9 Nestles Avenue

Design & Access Statement Addendum

18th November 2020 | 15406_L11_005_06

Drawing
Ground Floor Plan

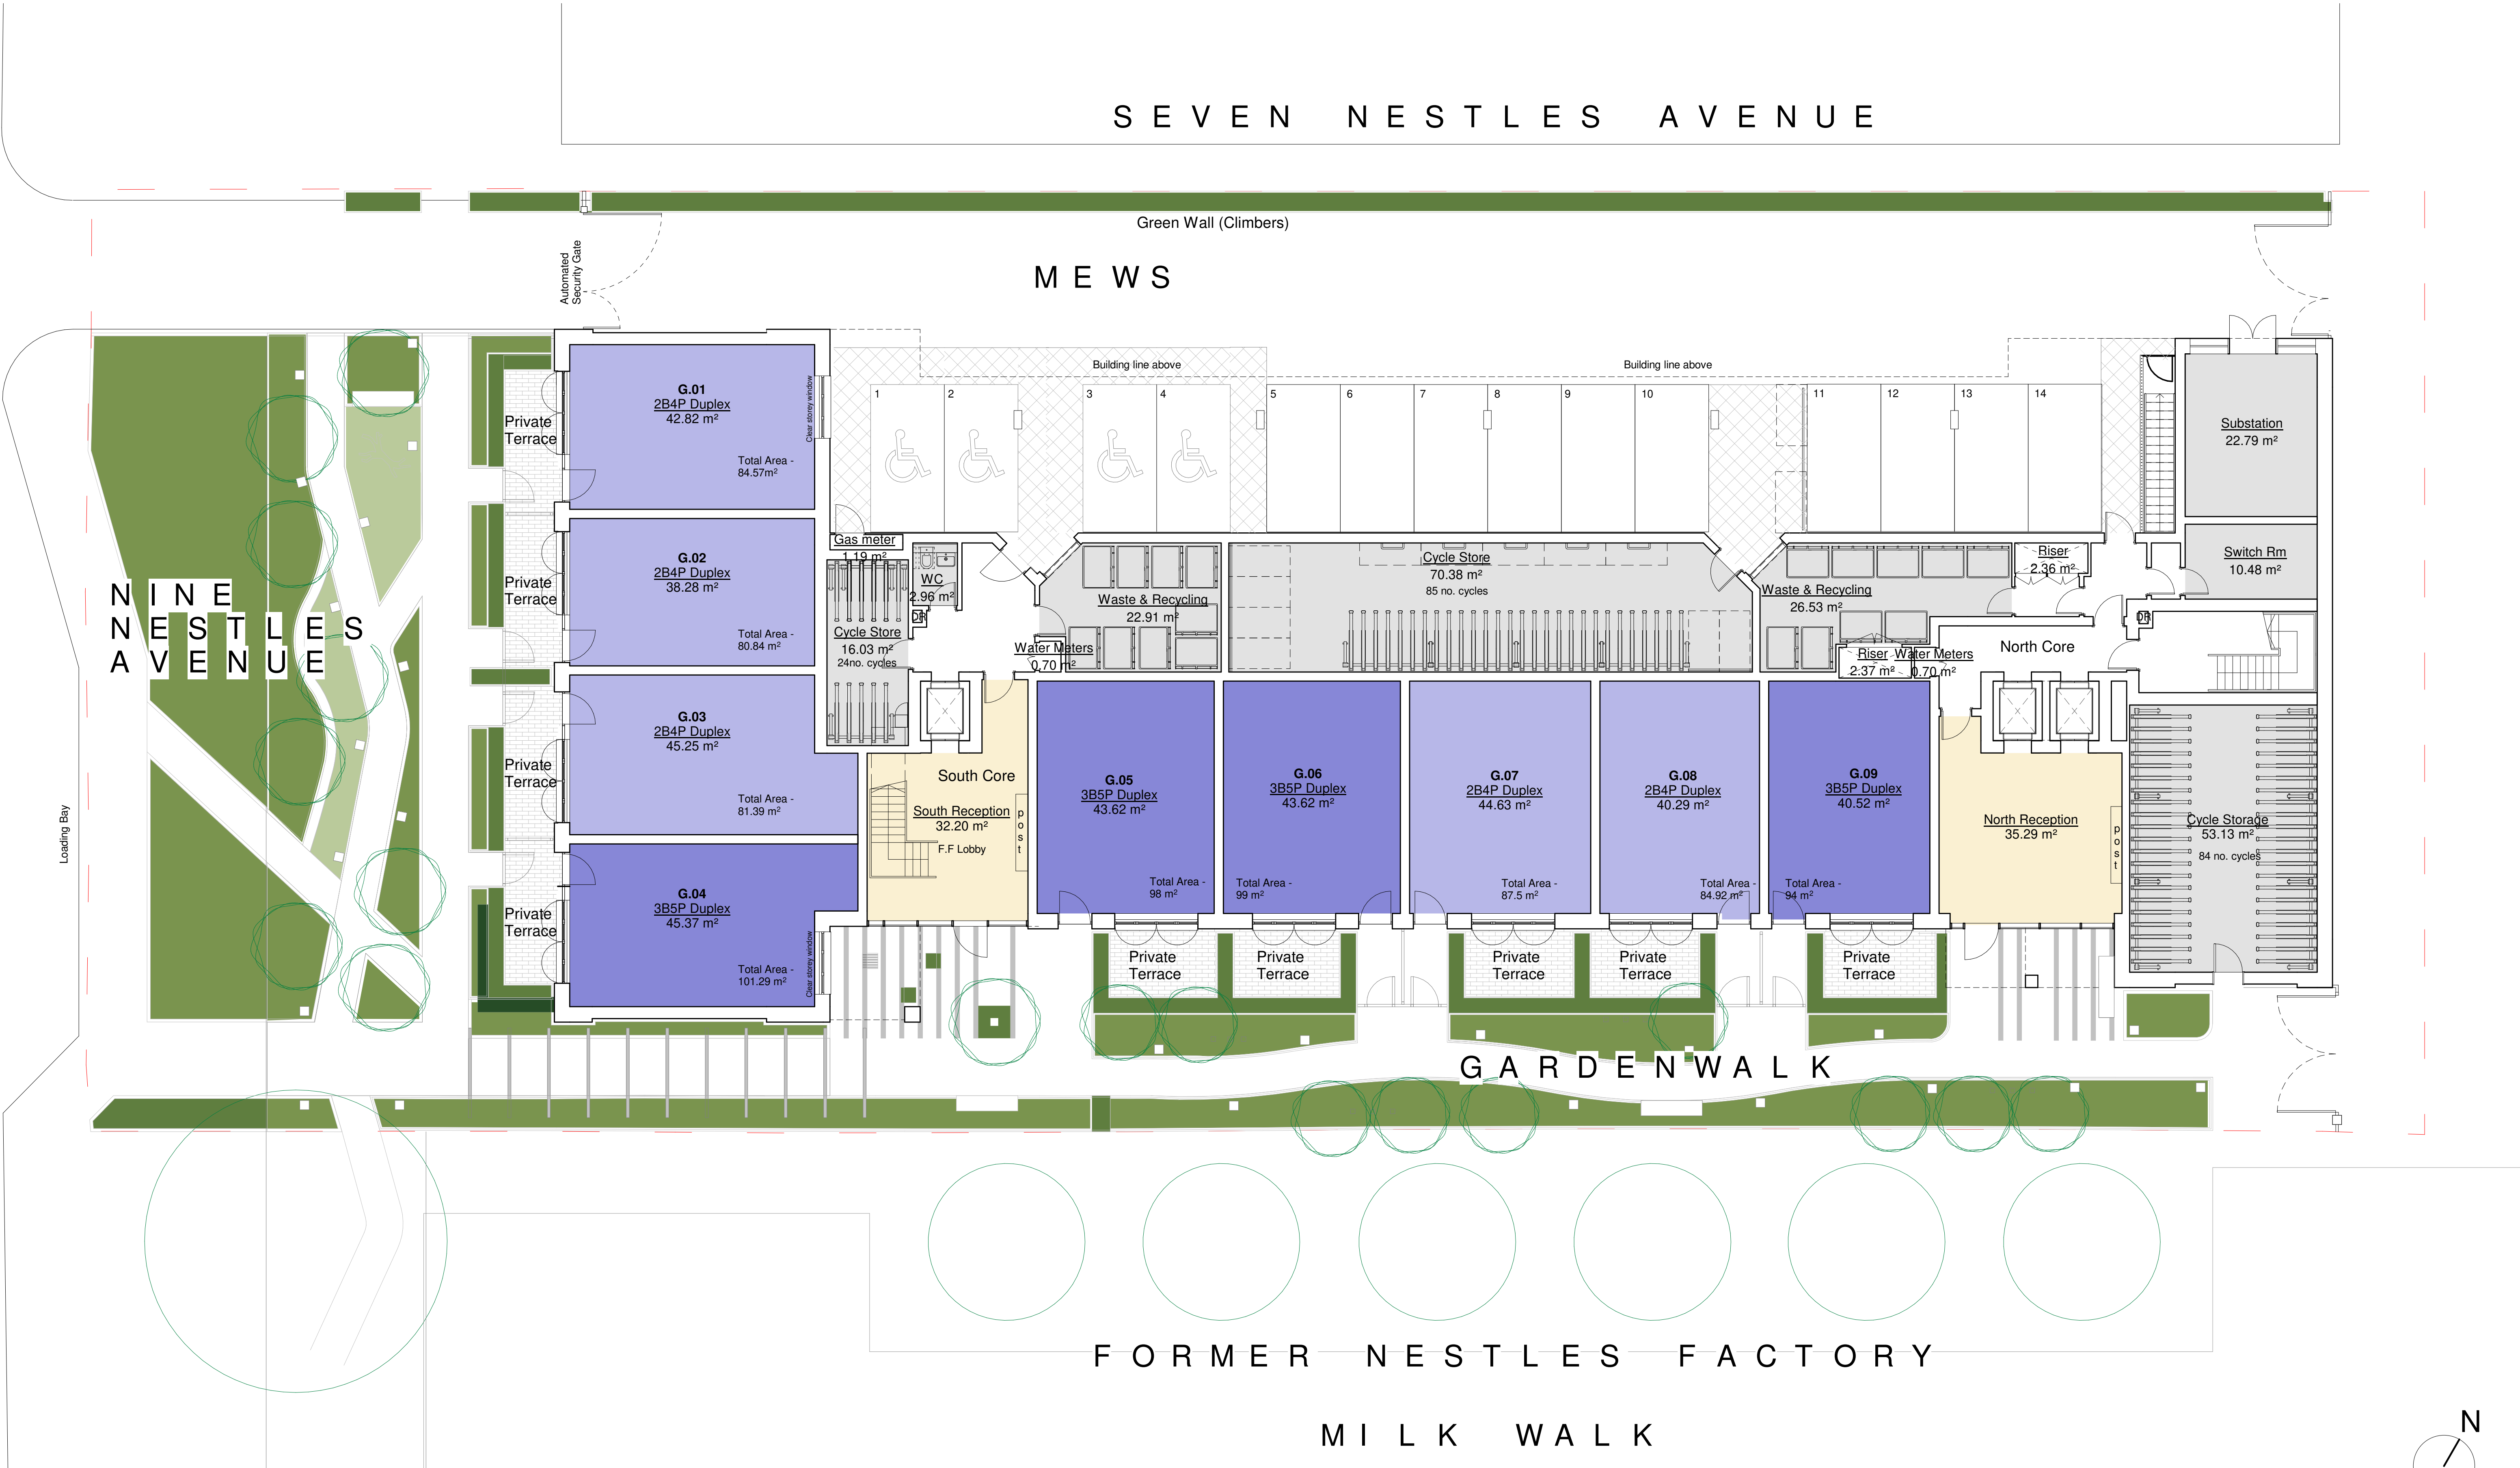
Officers have requested further details on the waste strategy.

A reorganization of the bin stores has created space for an additional 2no. bins in the south store (now 11 in total) and additional 1 no. bin in the north store (now 10 in total). This is to provide ‘float’ so that some bins can remain in the store on collection day. The stores are arranged with clear access to bins on both sides. All movement of bins will be by management on allocated collection days.

As a result to the changes to the bin store the central cycle storage has been reconfigured. Requirements for standard and non-standard cycle storage spaces are still being met.

The management plan overleaf has been updated to indicate the location for temporary storage of bins waiting for collection. These will be moved by building management personnel. Space allocation is based on half of the bins being collected on any given day. Temporary storage for bins waiting for collection still allows vehicles to pass into the mews.
